25 August 2026

The Secretary
NSW Department of Planning, Housing and Infrastructure

SSD-93539963 Mixed Use Development at 28 Cordeaux Street

REV 1.0
17/06/2026
A009 | SITE PLAN

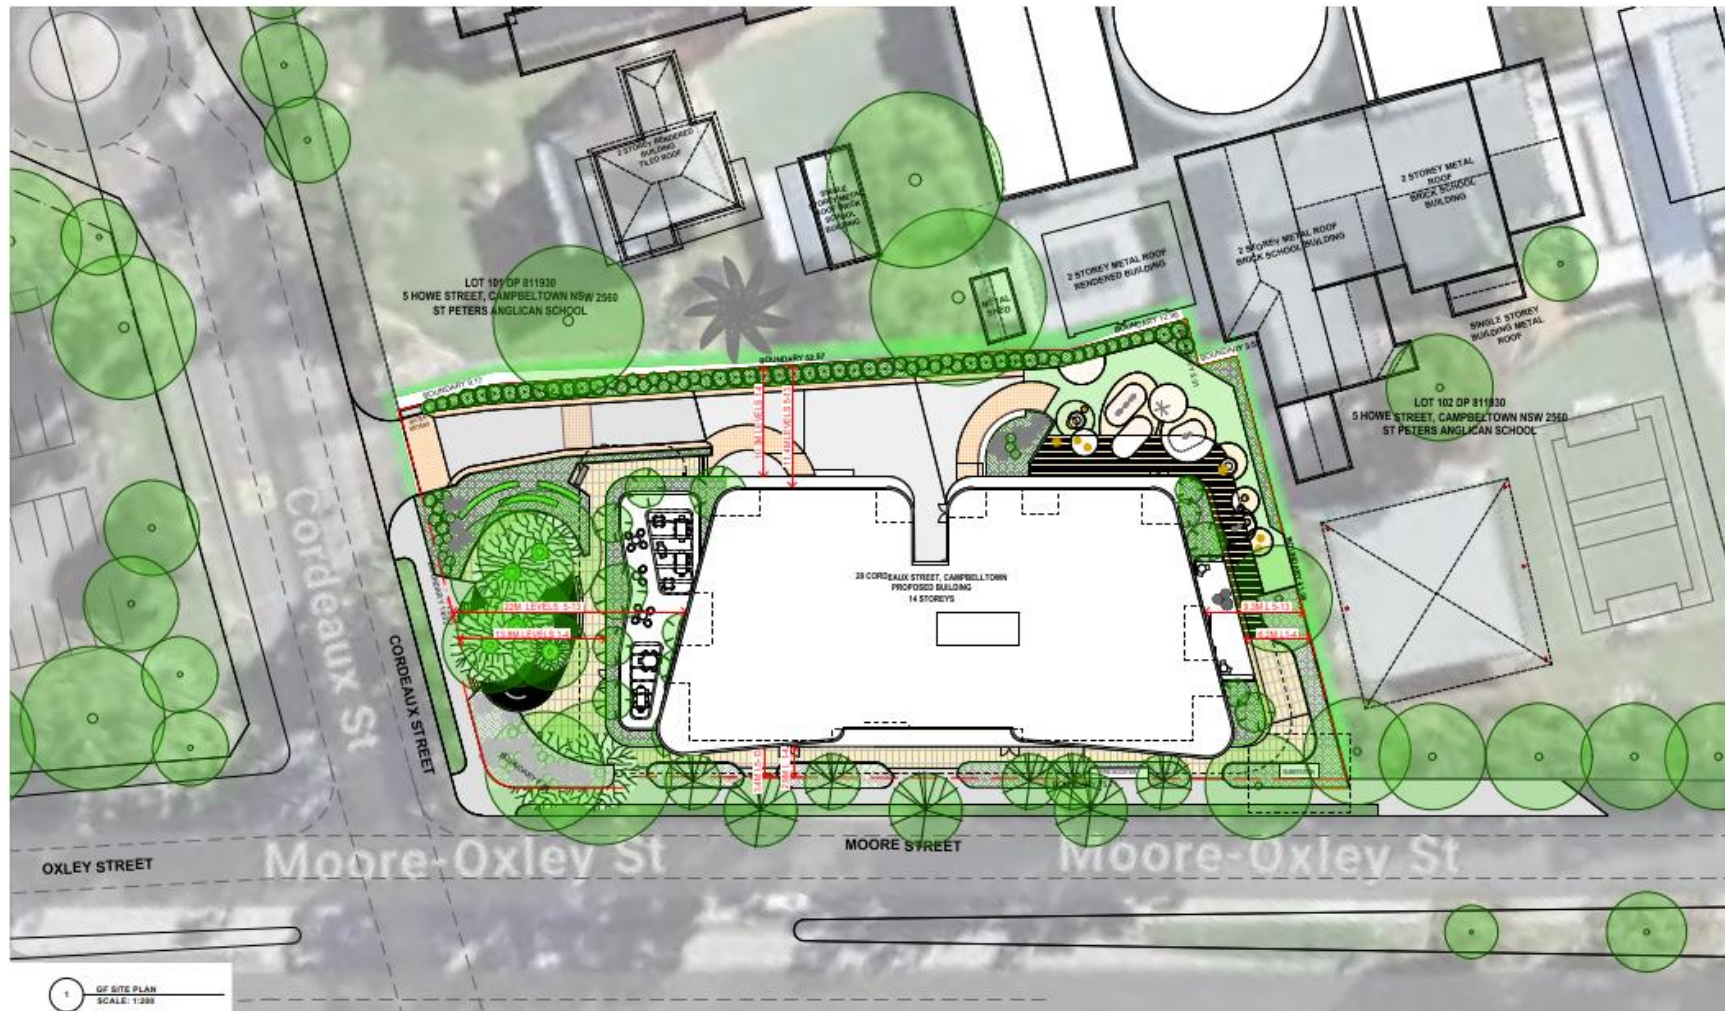
The EIS does not appear to address in detail whether electricity services are available and adequate for the proposed development. The below copy of the Site Plan shows provision of a 'Substation' to the south eastern corner of the site with frontage to the Moore Street road frontage.

Any required padmount substation/s will need to be located within the property (in a suitable and accessible location) and be protected (including any associated cabling not located within a public road / reserve) with an appropriate form of property tenure as detailed in the attached copy of Endeavour Energy's 'Land Interest Guidelines for Network Connection'.

Generally it is the Level 3 Accredited Service Provider's (ASP) responsibility (engaged by the developer) to make sure substation location and design complies with Endeavour Energy's standards the suitability of access, safety clearances, fire ratings, flooding etc. If the substation does not comply with Endeavour Energy's standards, the applicant must request a dispensation.
